KITTITAS COUNTY COMMUNITY DEVELOPMENT SERVICES

October 2, 2019

RE: Carney Boundary Line Adjustment (BL-19-00018)

TO: Community Development Services
FROM: Candie Leader, Administrative Assistant
DATE: September 30, 2019
SUBJECT: BLA BL-19-00018 (Carney)

PROJECT NO. 19157 SHEET 1 OF 2

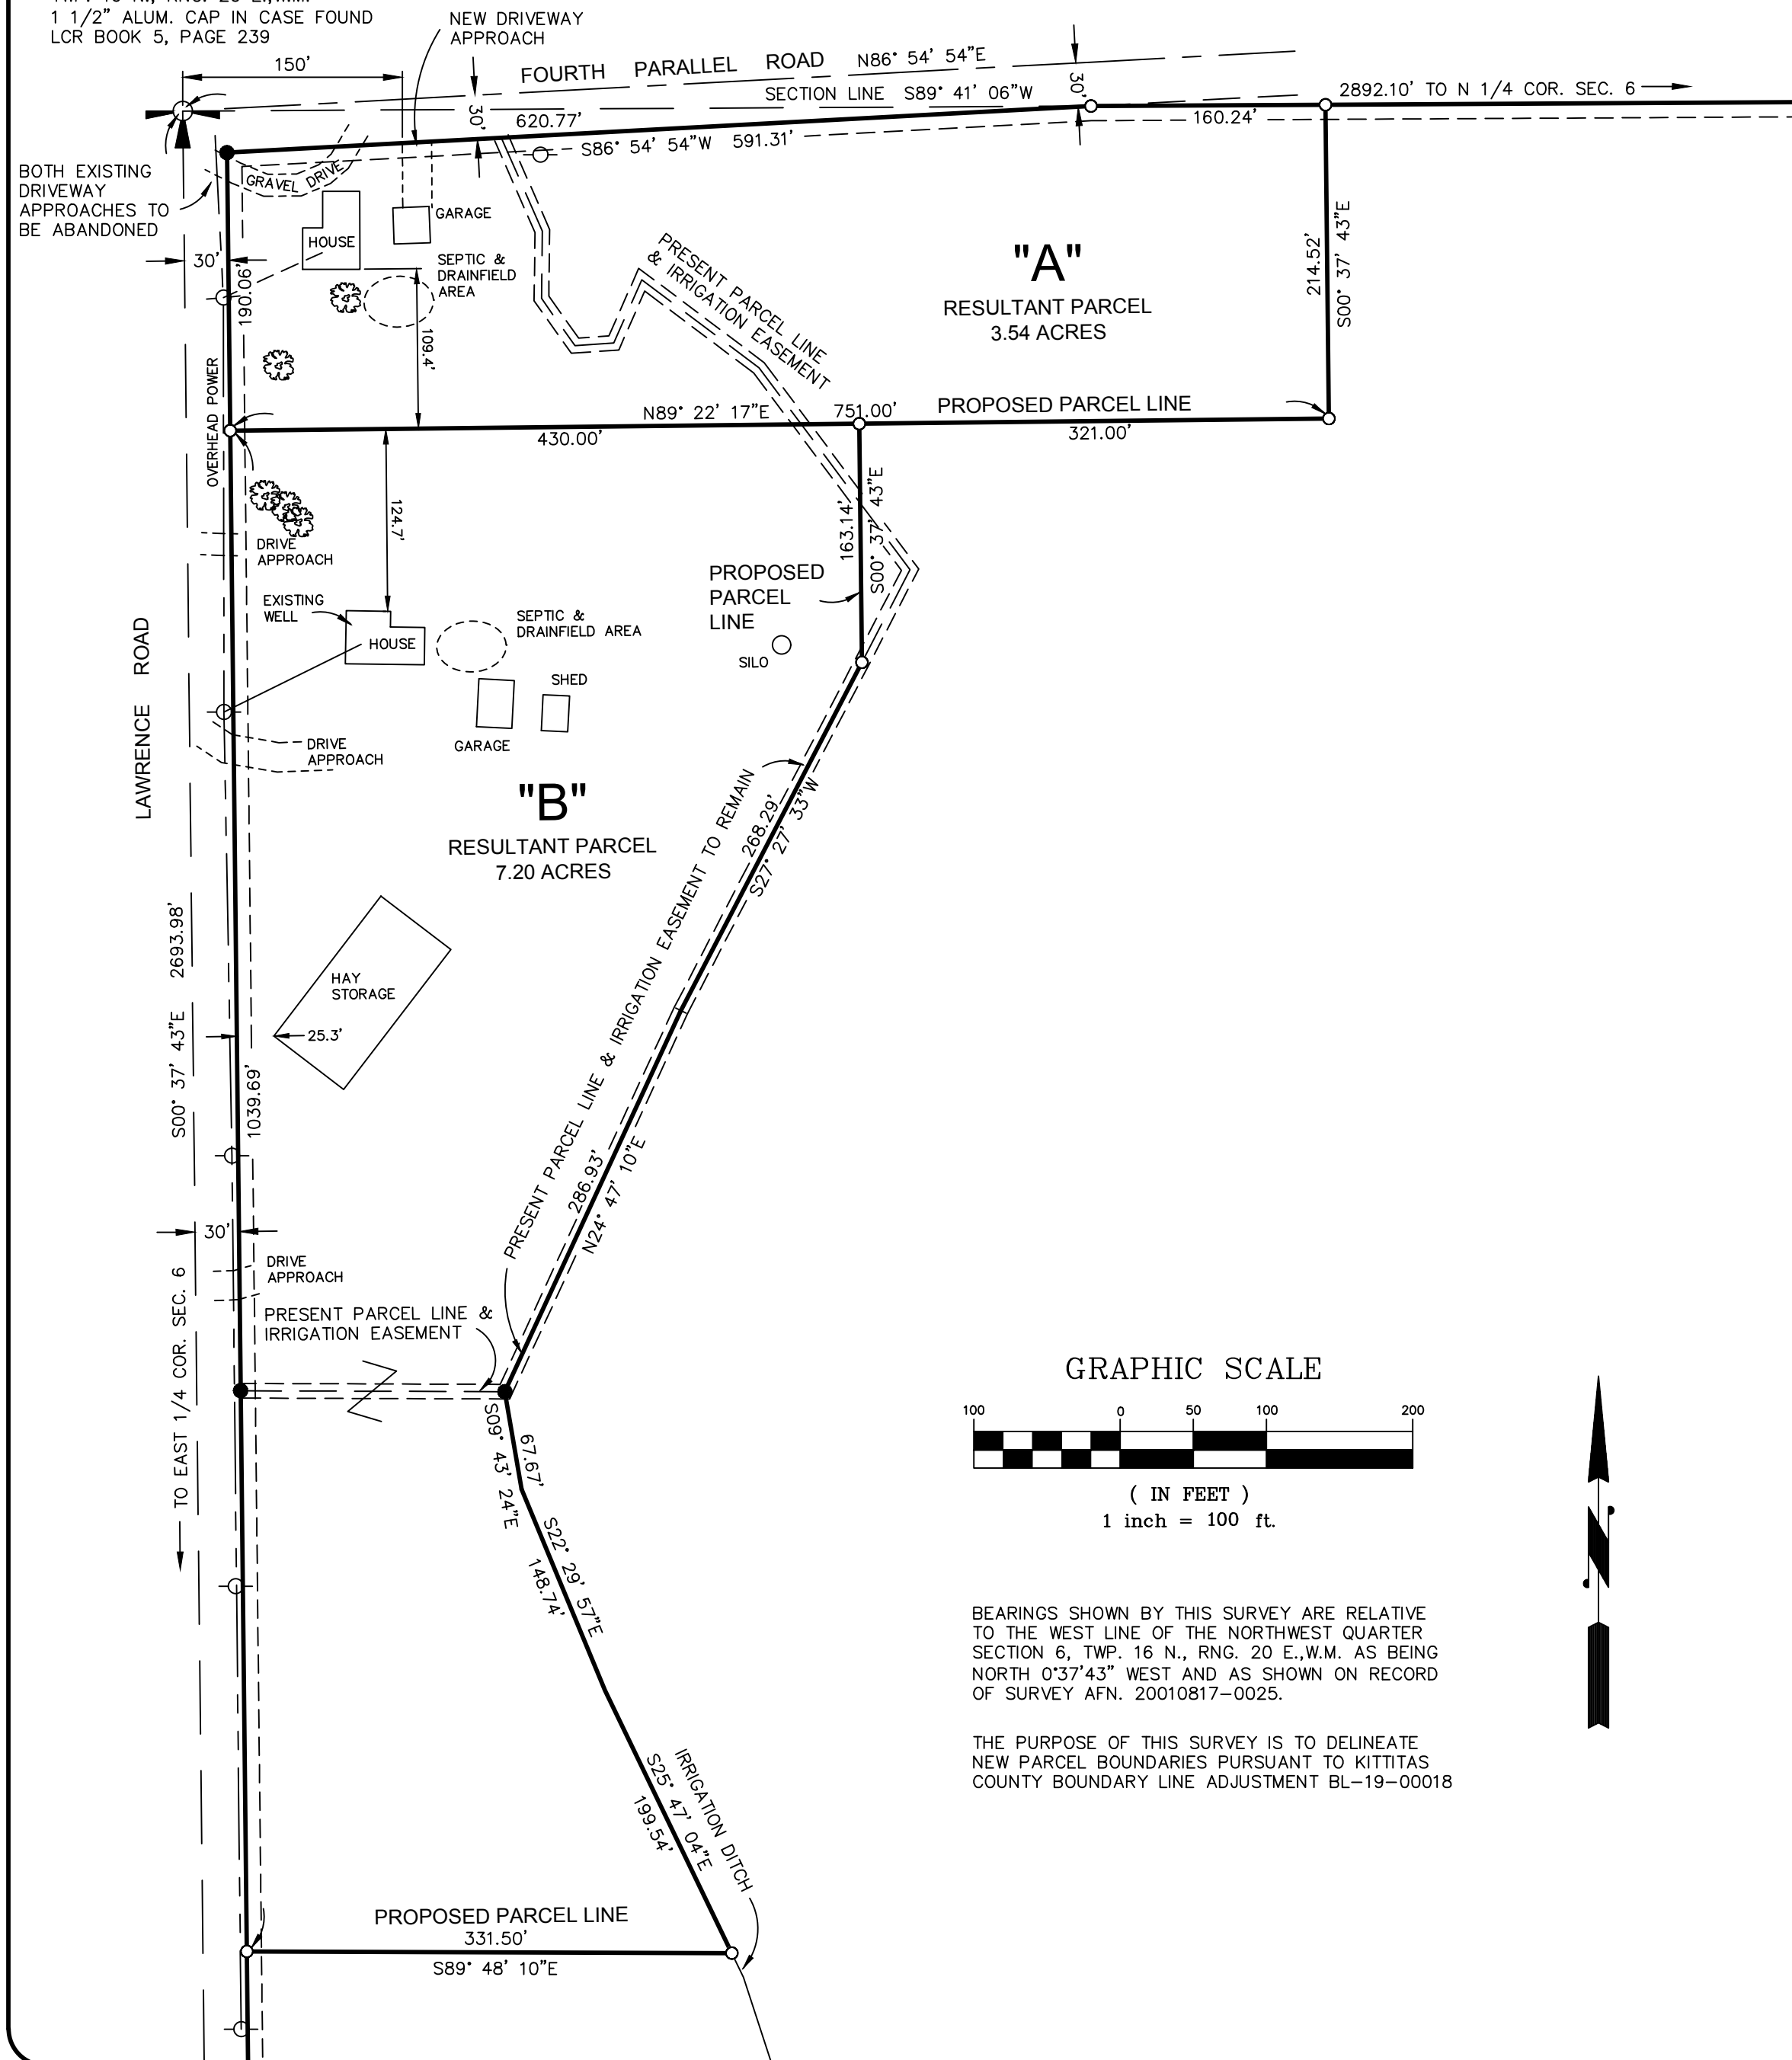
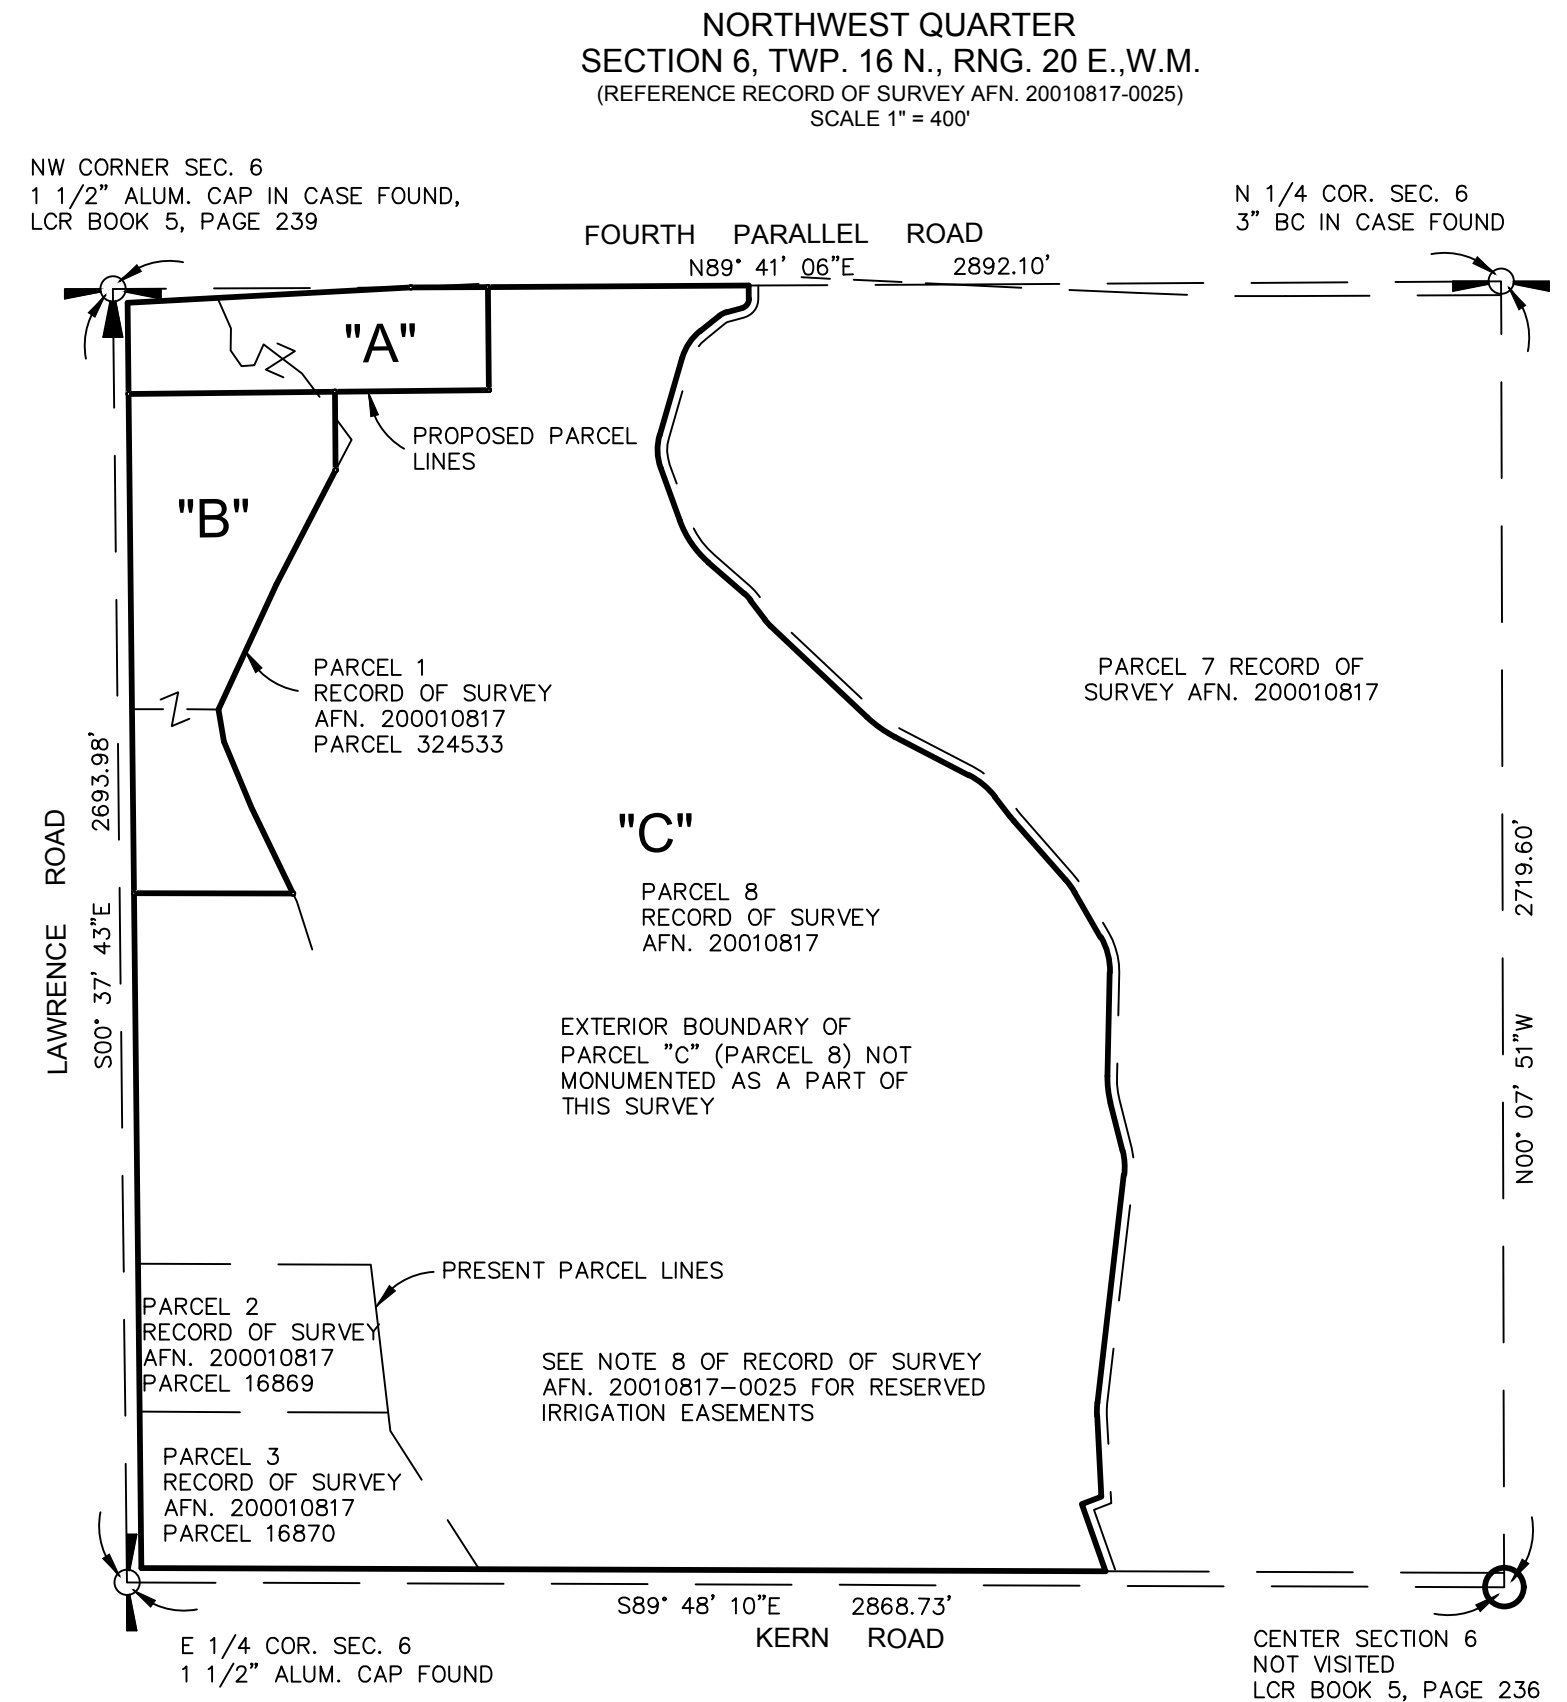
The proposed well that will be located on Parcel "A" to serve the existing residence will be required to meet all setbacks; 50 feet from all property lines, 50 feet from the existing septic tank and 100 feet from the existing drainfield and future replacement drainfield.

1. A revised legal description that describes the final configuration of the subject property shall be required.
2. A survey map for review
3. Show access easements on the face of the BLA

1. All roadways should show name, width, and underlying ownership.
(EX: Fourth Parallel Rd – 60' County R/W – Paved)
2. At minimum, the new division lines between the parcels should be staked in the field, with set corners shown on the face of the map.
3. The purpose of the survey shall be noted on the face of the map.
(EX: The purpose of the survey is to delineate new parcel boundaries for Boundary Line Adjustment BL-19-00018.)
4. The Record of Survey referenced on Section Map located East of Parcel C is incorrect.
5. Typo on "Preliminary" within title block.
6. Section Township and Range Shall be shown in Bold text near the top of the page
(EX: Pt of NW 1/4 Sec 6, T16N., R20E, W.M.)
7. Location within title block does not encompass all of the proposed BLA.
